DECISION DELEGATED TO HEAD OF PLANNING

Application No: H02-0715-24 **Applicant:** Mr I Collins
Proposal: Erection of detached dwelling
Location: Rear Of 60 Peterborough Road Crowland Peterborough
Terminal Date: 30th October 2024

Client:	MR. I. COLLINS	Proposal:	PROPOSED NEW DWELLING R/O 60 PETERBOROUGH ROAD, CROWLAND	Scale @ A3 1 : 100	Title PROPOSED ELEVATIONS INDICATIVE DWELLING
	JANICE KENDRICK DESIGN SERVICES		e-mail- jkds@talk21.com tel : 07711 007209	Dwg No. 24. 3575. 03

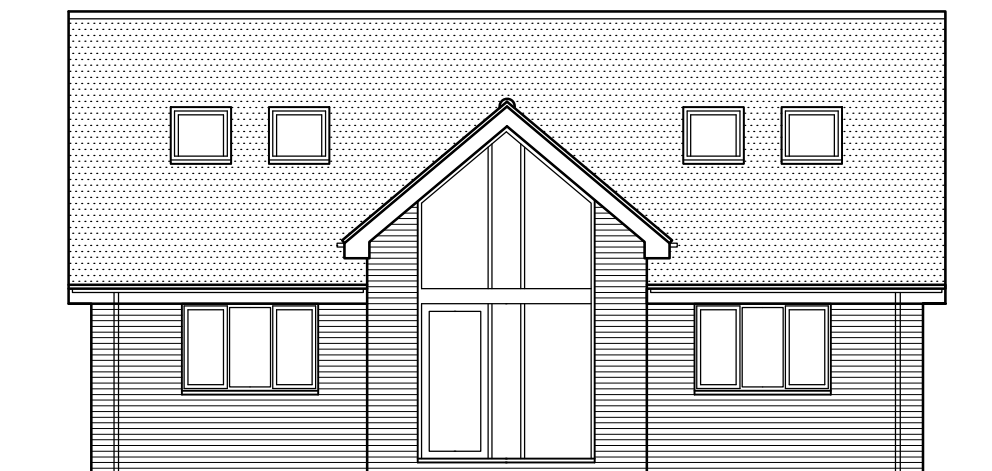
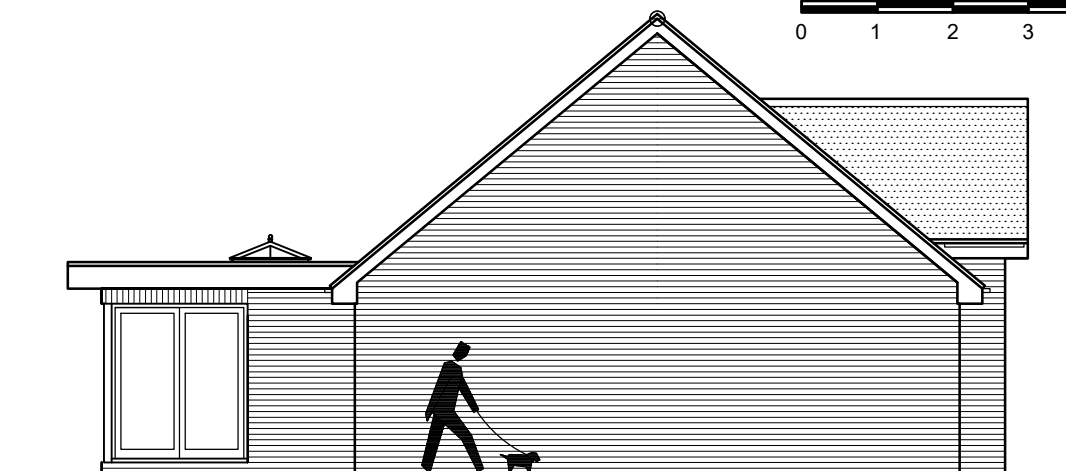
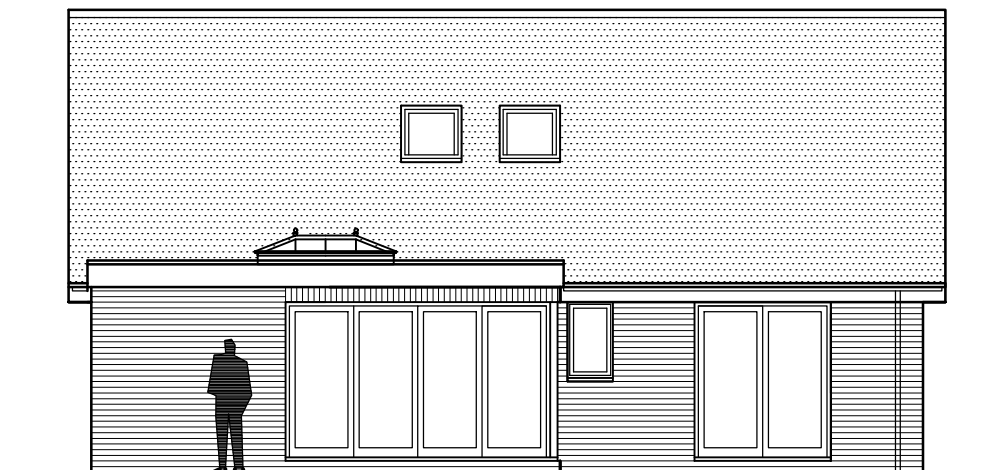
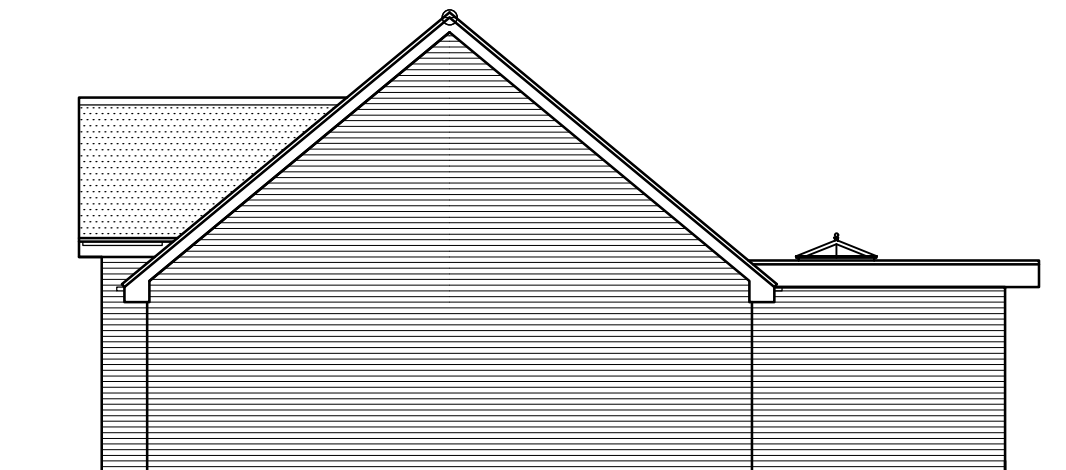
The design and access statement describes a two bedroom chalet bungalow. The Environment Agency does not object to the proposal as long as the development is 2 stories due to flood risk. It should be noted that the existing property on the original plot is a bungalow, so the new dwelling would be larger in comparison with the host dwelling, which is within the blue line of the application site. There is confusion within the information associated with the finished floor level of the proposal contained within the Flood Risk Assessment, given that floor levels in that document were set at 11.35m. Clarification has been sought from the agent, that the the finished floor level of the dwelling would be 1 metre above surrounding ground levels. This accords with the response from the Environment Agency, who said it would need to have a 1m finished floor level to mitigate flood resilience. This would make the structure taller, and higher than number 60 Peterborough Road.

The dwelling also creates a new building line at the rear of plots along Peterborough Road, which is incongruous and out of keeping. It is also taller than number 60, and in close proximity. It is considered in terms of outlook, size and bulk, the rear outlook of number 60 would be dominated by the structure itself. In terms of privacy, the two dwellings would directly face each other offering virtually no privacy.

Client:	MR. I. COLLINS	Proposal:	PROPOSED NEW DWELLING R/O 60 PETERBOROUGH ROAD, CROWLAND	Scale @ A3 1 : 500	Title EXISTING BLOCK PLAN
	JANICE KENDRICK DESIGN SERVICES		e-mail- jkds@talk21.com tel : 07711 007209	Dwg No. 24. 3575. 01

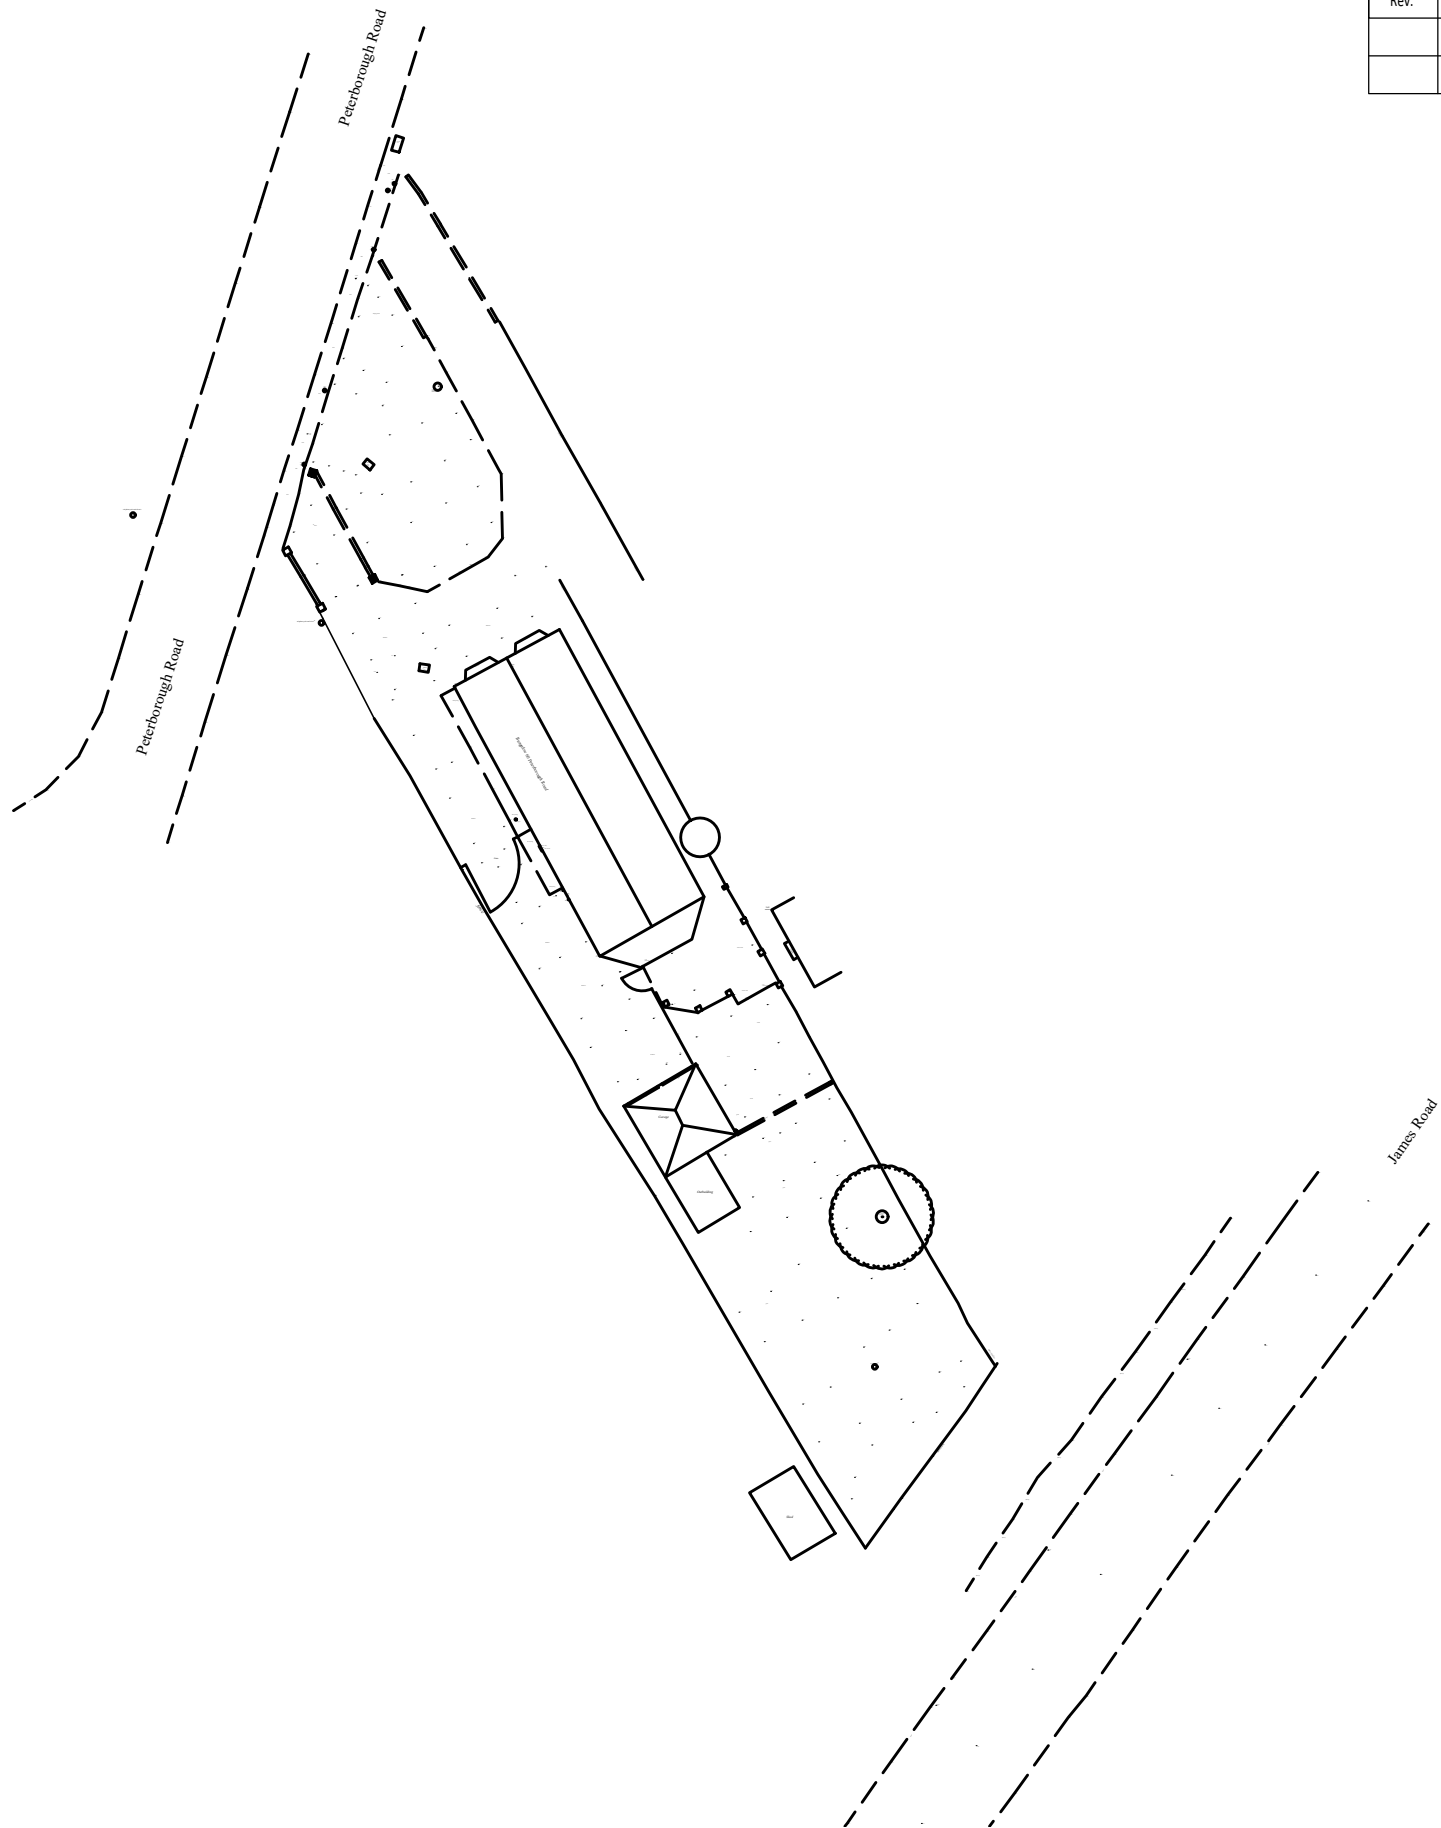
We would not allow individual access points onto James Road - there is no footway connection into the Village. Access should be from the existing access on Peterborough Road. The access would need upgrading to 4.1m wide for the 10m and there after it shall measure 3.7m wide.

The current proposal cuts in half the traditional long, narrow plot that borders both Peterborough Road and James Road. The resulting rear garden of the proposed dwelling would be 5.17m within the sub-divided plot, producing a rear garden of 7.61m for 60 Peterborough Road. The dwelling would face James Road with the rear aspect facing 60 Peterborough Road. The facing distance between the existing and proposed dwelling would be 12.62m. This would be a cramped form of development, with much reduced amenity space for both properties. It is accepted that 58 Peterborough Road is 'backland' development, but that was approved 21 years ago when the National Planning Policy Framework did not exist, nor was the SELLP in place. This newer policy framework, together with the National Design Guide/Code, collectively has an increased emphasis upon design.

Breaking up the long narrow plot, creates a development which is out of keeping and out of character of the prevailing development in the immediate vicinity. Creating an access onto James Road is also a new, discordant feature in terms of the character of the group of similar dwellings, as is the facing of the dwelling onto James Road. It is accepted that newer development behind 54 Peterborough Road would represents a change to that particular location by infilling the currently open ground, but that development is distinct and in design terms is arranged around its single access point. It is not considered that that development is comparable in design and character terms with the current application, particularly as the current proposal relates to sub-dividing a historical plot which retains the centrally positioned single storey dwelling. The current application site is part of a historical pattern which is distinct from the more recently approved scheme.

The proposal seeks access onto James Road, over the top of an IDB drain, and proposes a gravelled area in front of the property which would face James Road. The layout shows two car parking spaces. As the dwelling contains two bedrooms the proposal is capable of meeting the car parking standards in Appendix 6 of the SELLP. No provision for cycle parking is shown, but it is expected that had the proposal been otherwise acceptable, a condition requiring the installation of a cycle rack on the exterior of the dwelling prior to occupation would satisfy the cycle parking requirement.
